Application No: FP/76/22/DOC
Registered: 5th May 2022
Site Address: Land North of Felpham Felpham
Description of Works: Approval of details reserved by condition imposed under FP/248/20/PL relating to conditions 8-levels, 12-surface water drainage, 13-discharge flows to watercourses, 14-maintenance and management of surface water drainage system and 21-Landscape and Ecological Management Plan.

Date: 16/09/2022

Planning Reference: FP/76/22/DOC

At this stage we would not recommend discharge of conditions until the following comments are addressed in relation to conditions 8,12,13 and 14 (FP/248/20/PL)

Title Easement Layout

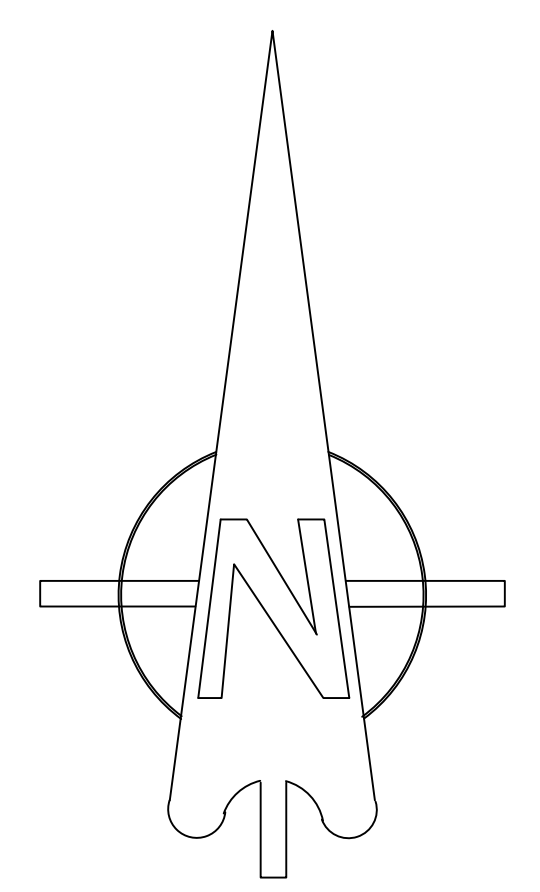
Maximum water level in the ditch needs to be shown and clarification in relation to the potential interaction with the adjacent building and foundations

The current typical section detail of the swale is insufficient. A detailed cross section construction and construction details of the extended swale is required with clear information provided on the base and top of bank levels as well as how the banks tie in the adjacent existing and proposed levels.

Drawing Title
Proposed Drainage

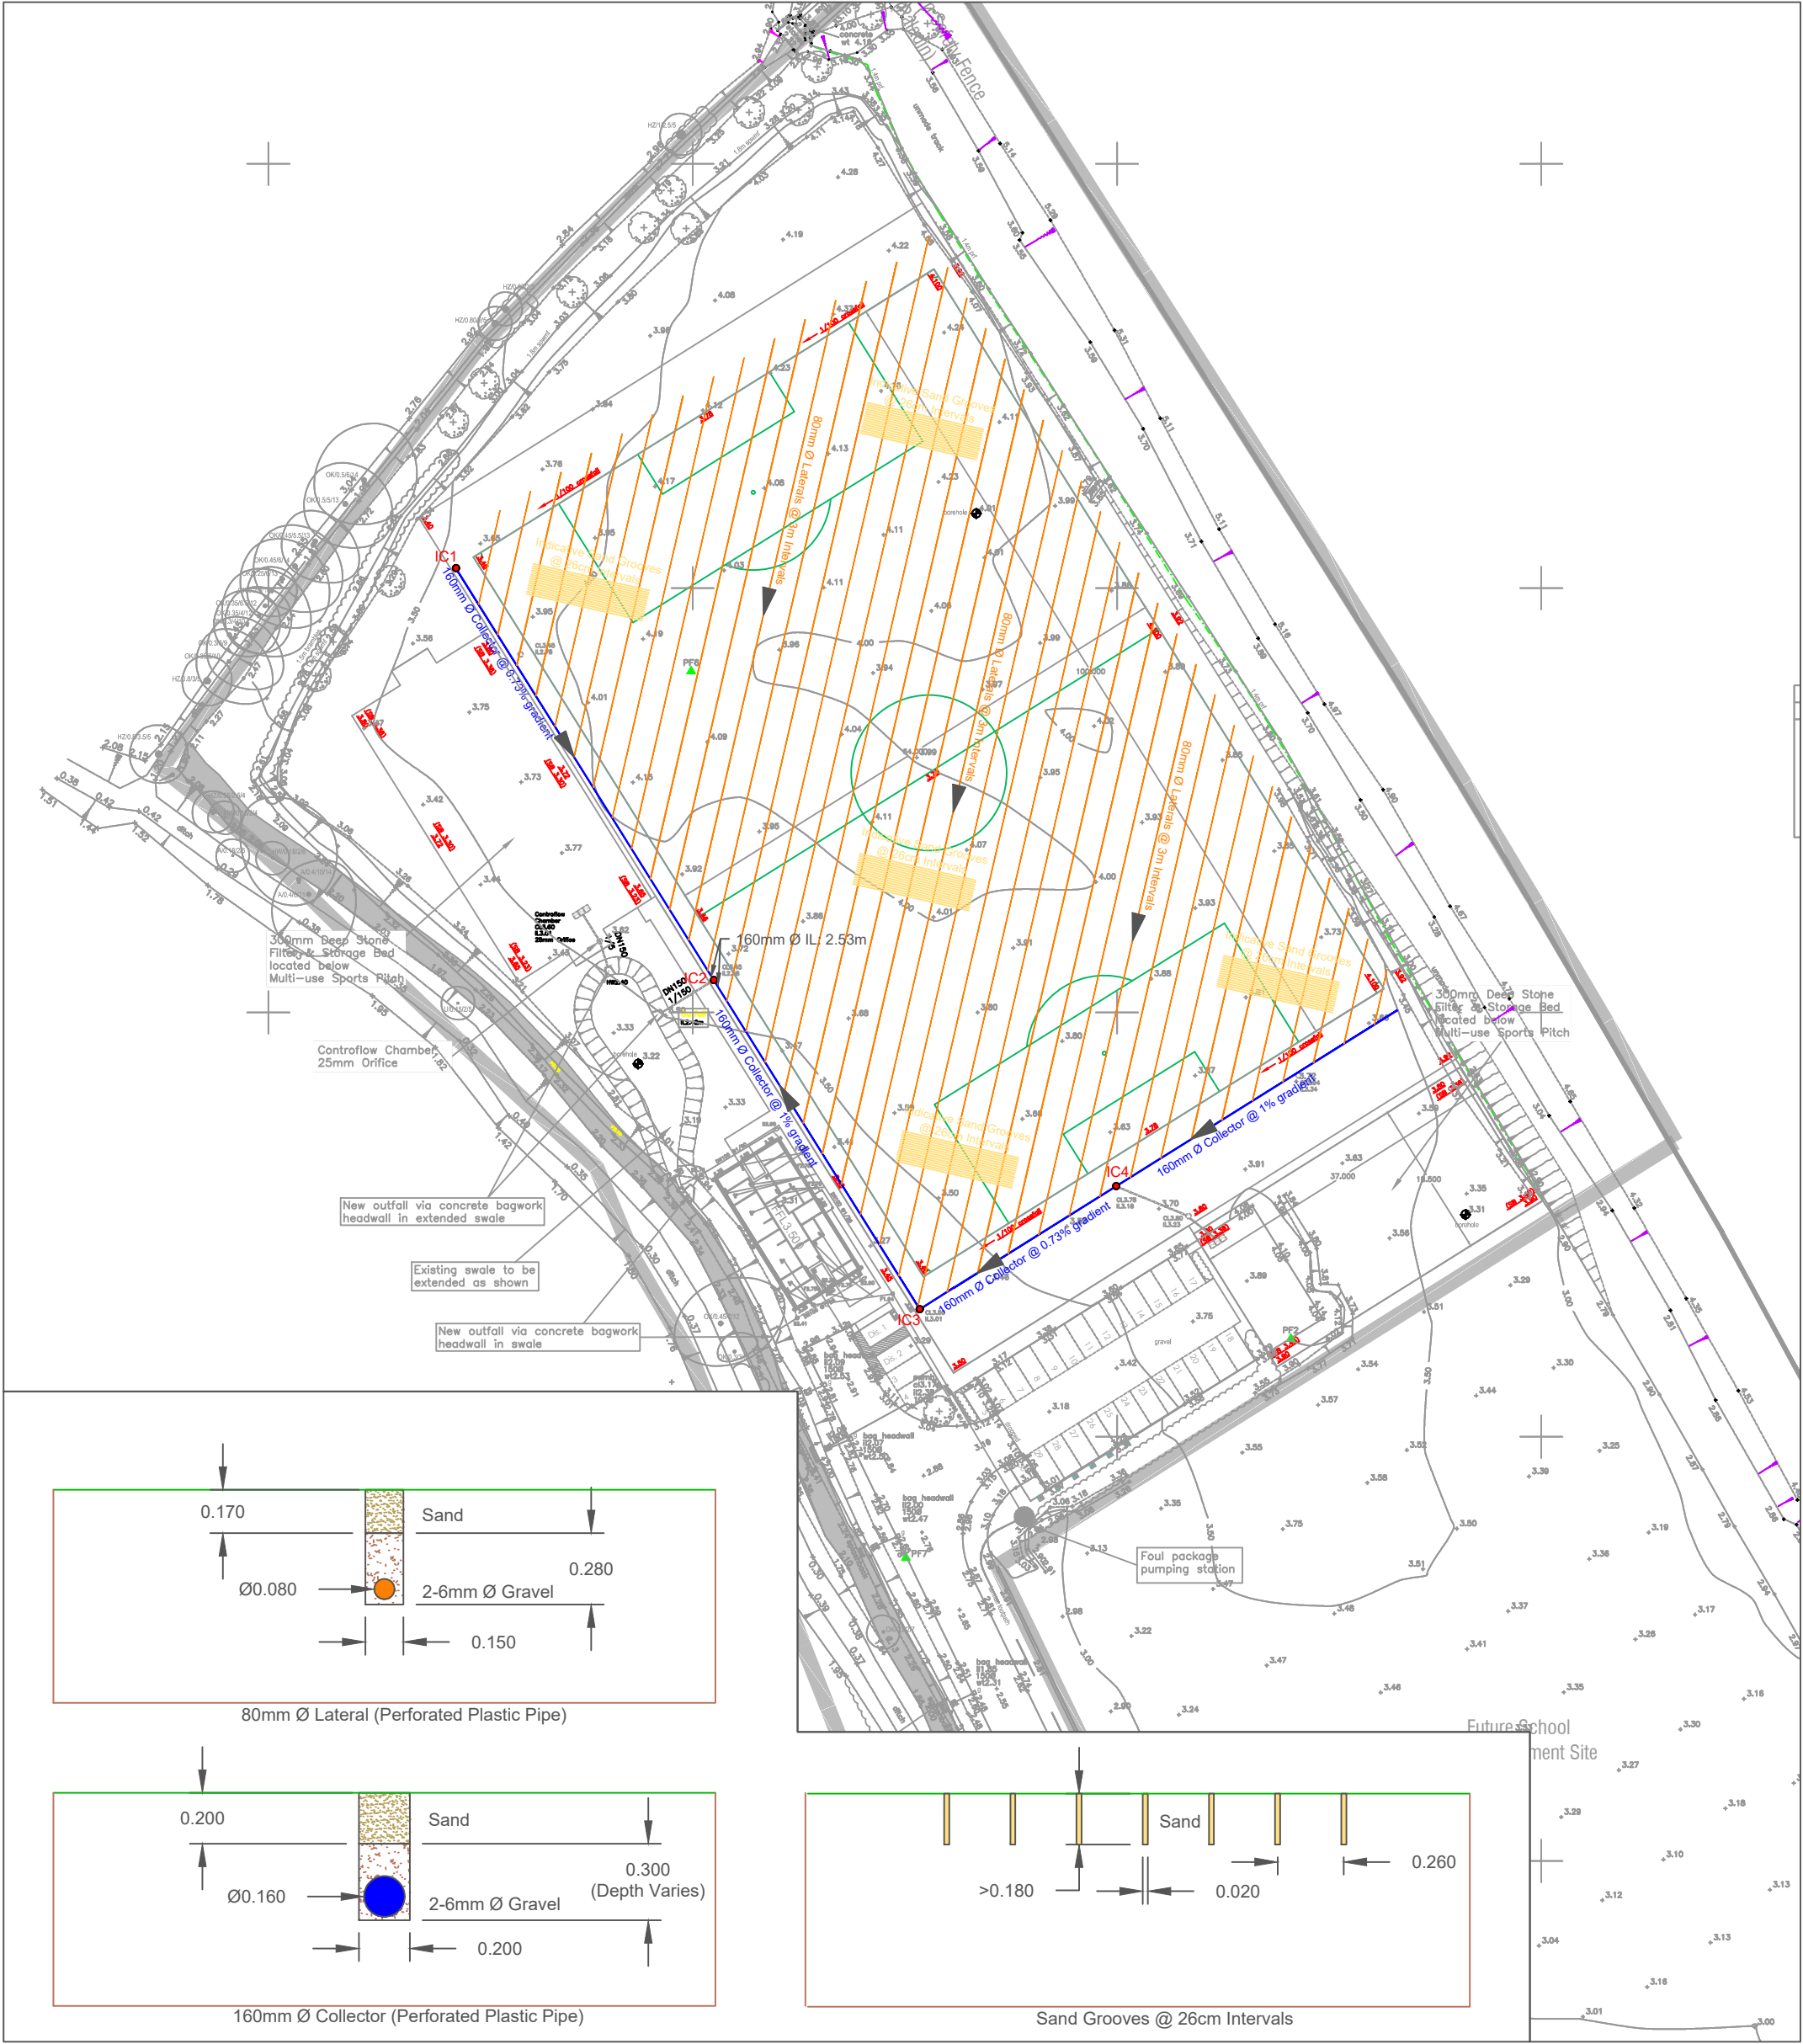
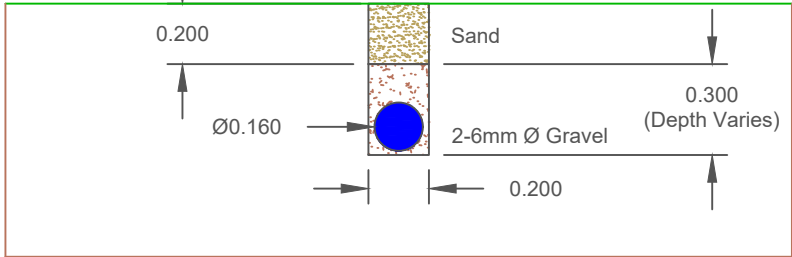
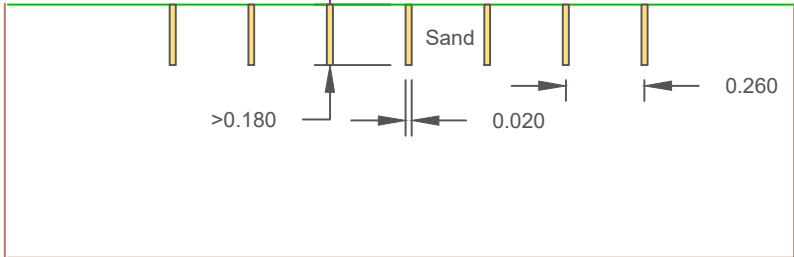
No infiltration testing to BRE 365 is provided. This is required to determine whether infiltration techniques can be used on this site, including any shallow infiltration potential in the Multi-Use Sports Pitch,

Clarification on the function and interaction of the storage bed below the multi-Sports pitch, in relation to the wider surface water design needs to be provided. Based on the current lowest level of the proposed main playing pitch (3.40m) and the design of the formation level of the storage medium (3.38m) would indicate only 20mm of potential storage being offered.
